PROPOSED LIDL FOODSTORE

**Former Hayes Pool and Fitness Centre,
Central Avenue, Hayes Town**

**Addendum Transport Assessment:
Appendices A - E
On behalf of Lidl UK**

Response to Highway Officer Comments

drawing number	rev
15/0302/TK03	B

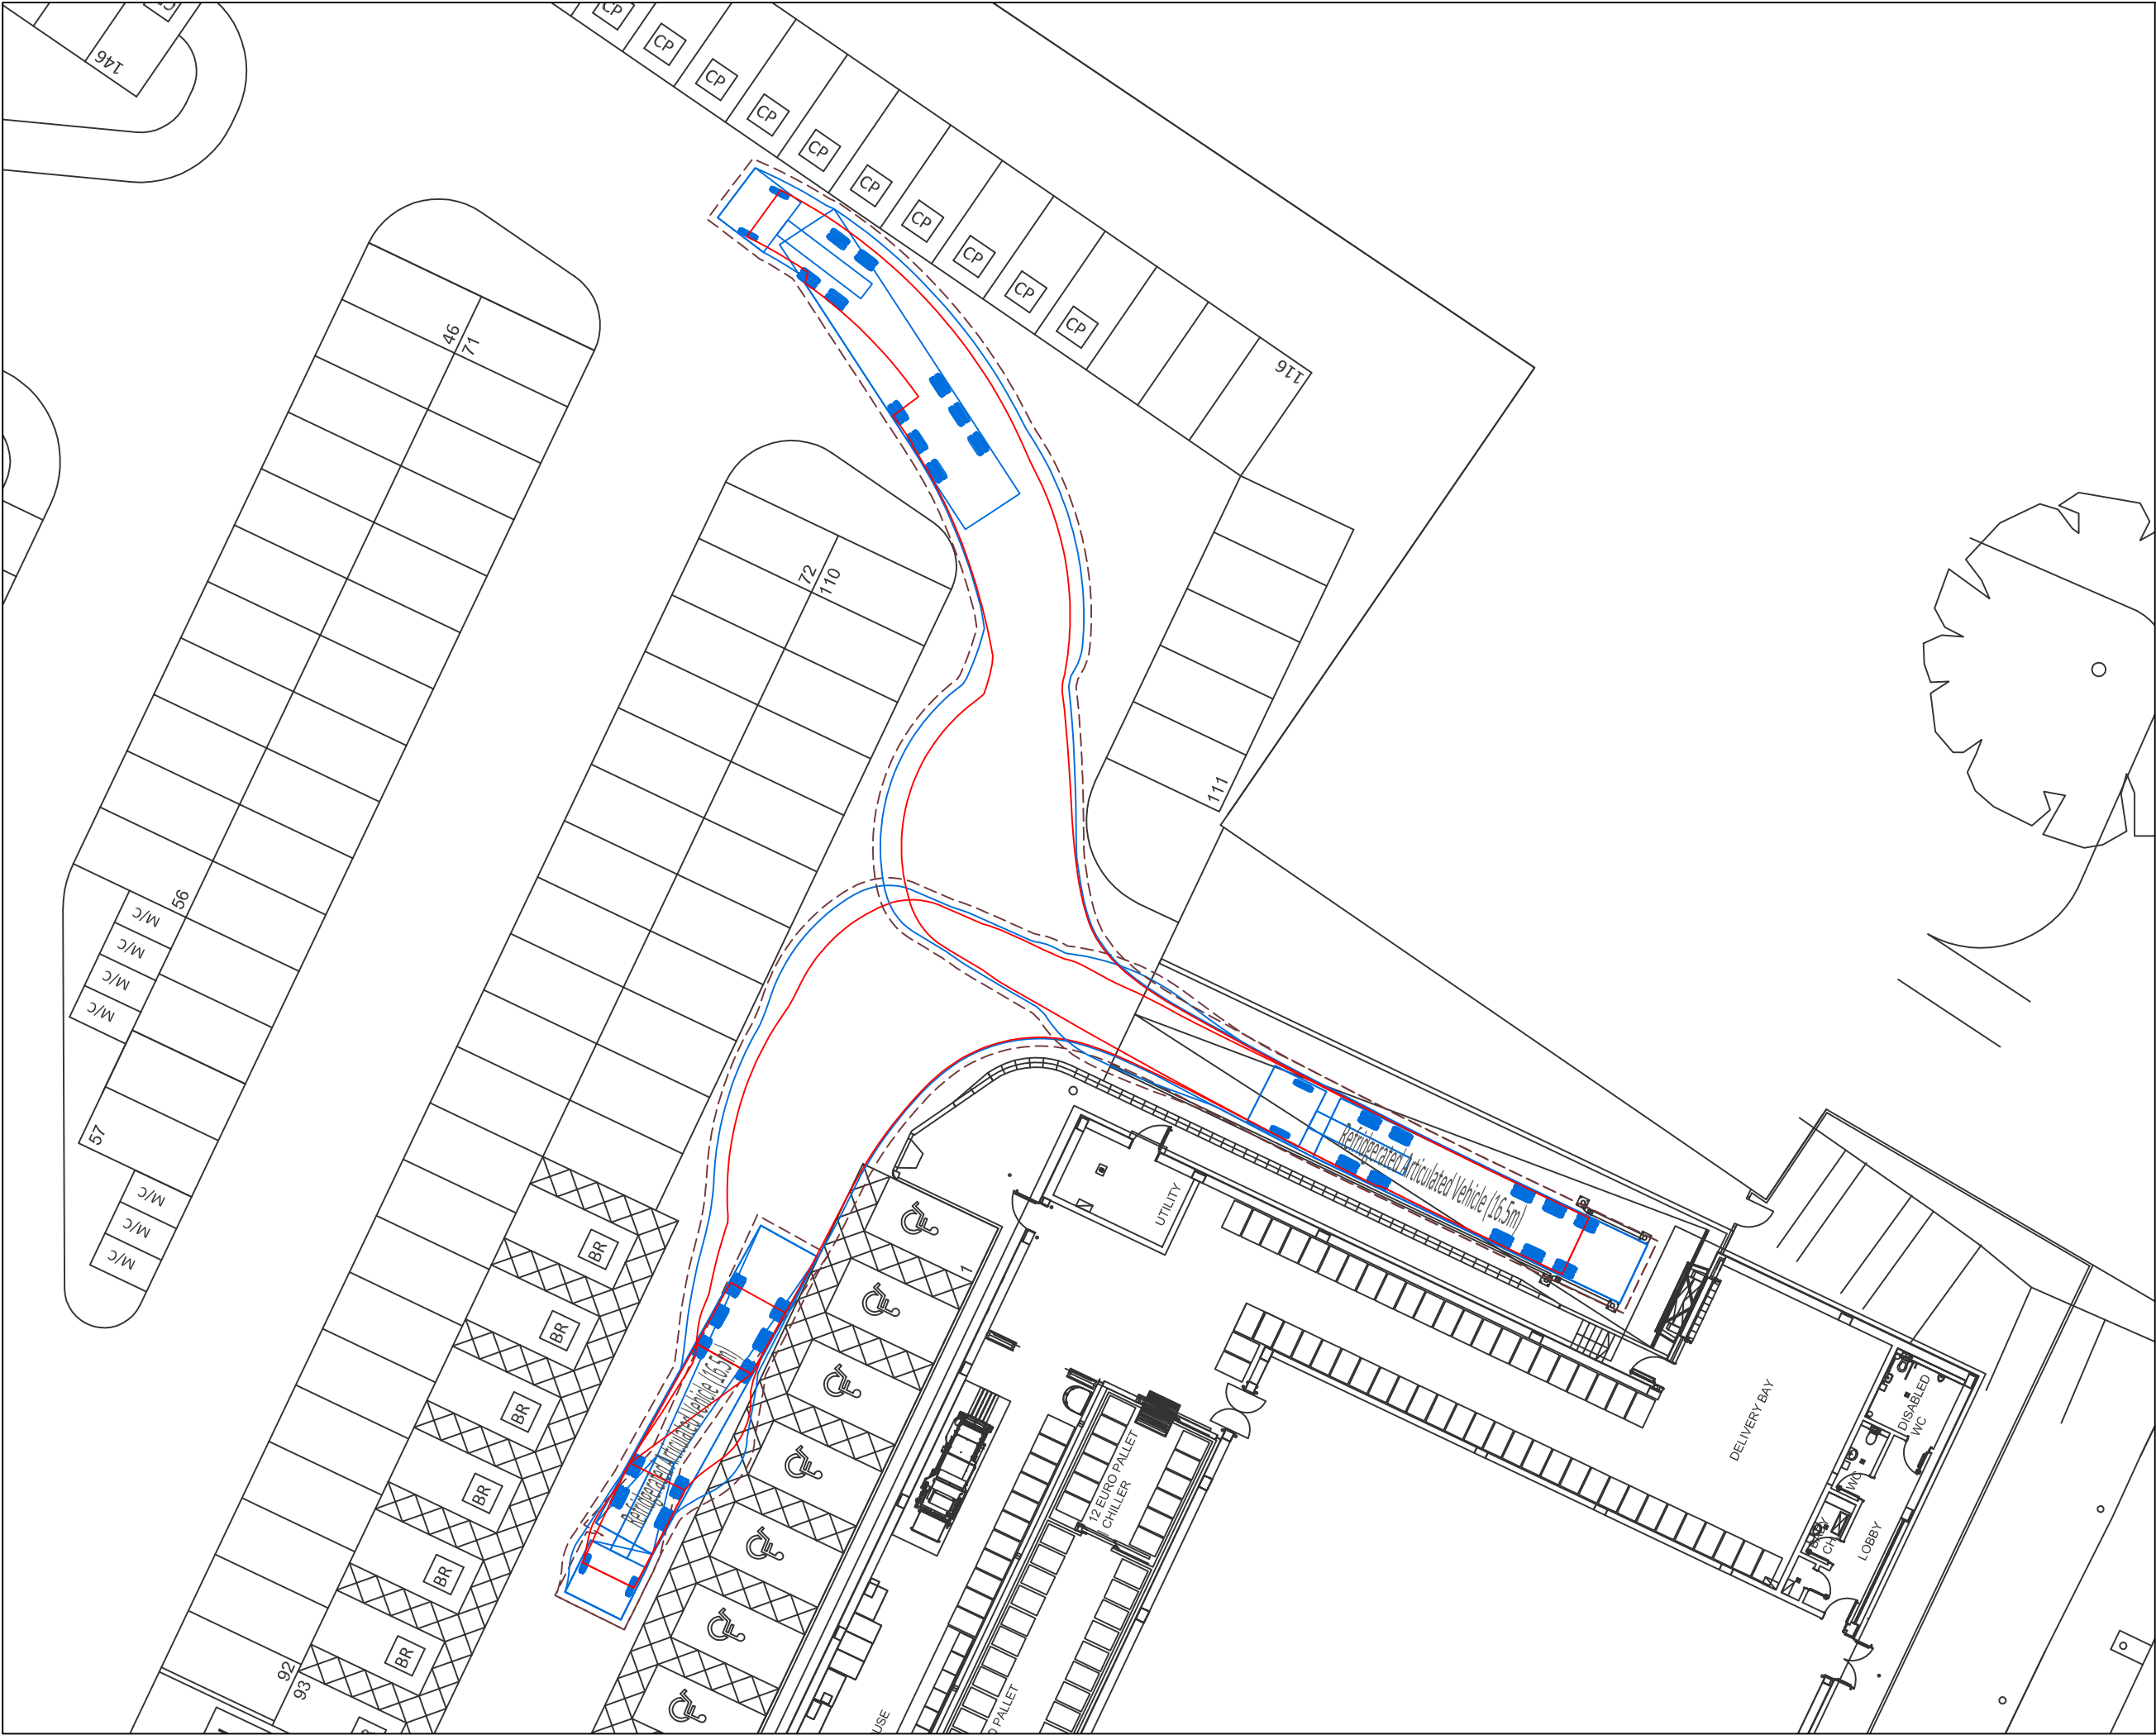
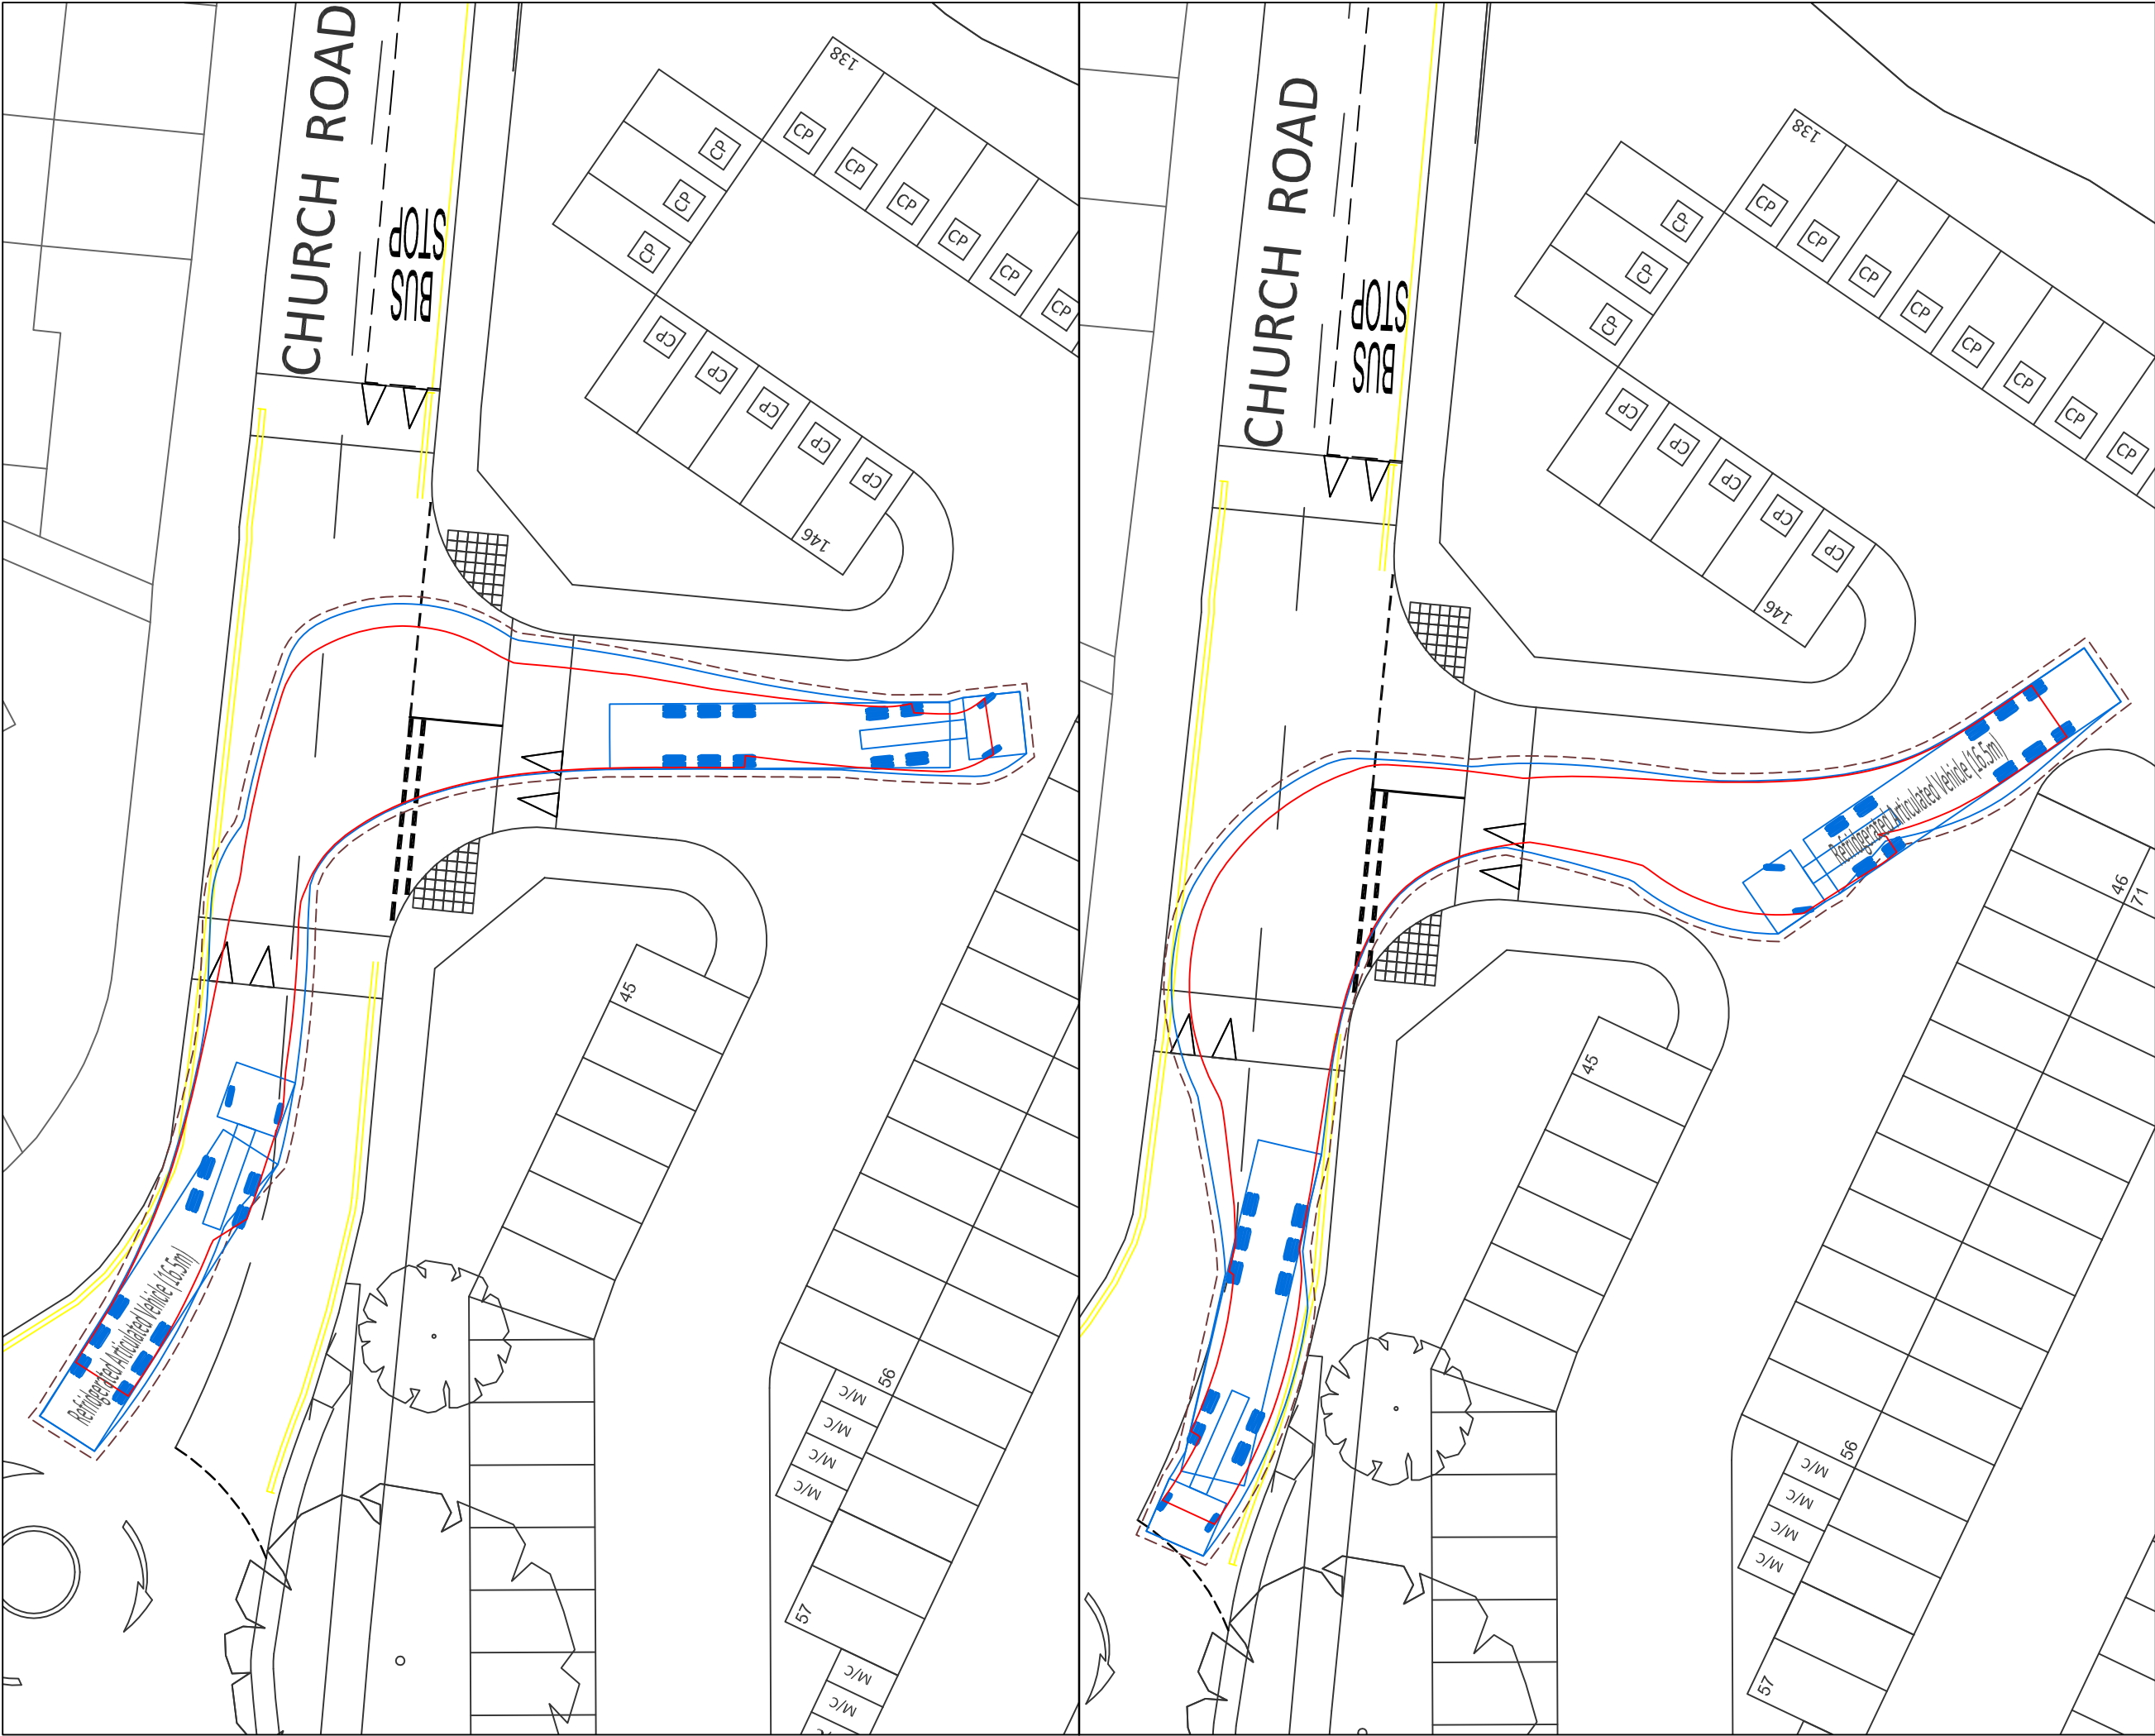
“The proposed service access arrangements are unsatisfactory. The swept path analysis shows the requisite turning movements of delivery vehicles cannot be satisfactorily accommodated on the existing road layout and the proposed access, even in precision driving conditions. The manoeuvring within the site is far from ideal and in part relies on rear transfer space for disabled parking spaces. A designated service access should be provided from Central Avenue.”

- 13** The vehicle swept paths provided within the Servicing Management Plan at Appendix J of the Transport Assessment indicate that a 16.5 metre articulated vehicle can successfully access the site and servicing area.

- 14** Additional swept paths have been provided post-application submission to demonstrate that vehicles can access the site via Botwell Lane in either direction, with vehicles able to traverse the roundabout to access and egress Church Road. On this basis, it can be considered that the existing road layout can accommodate the delivery vehicles associated with the site.

- 15** The servicing arrangement provided at the site is no different to that which was approved during the previous planning consent at the site (reference 1942/APP/2013/3565), which included delivery vehicles reversing past the site access to enter a dedicated servicing area. This application provides a net benefit to the site, with the reversing distance of the delivery vehicle reduced accordingly. In addition, no reversing manoeuvres are undertaken in the vicinity of the site access, reducing the risk of conflicts at the site access and the potential for queuing on the local highway network as vehicles wait for the servicing manoeuvres to be completed.
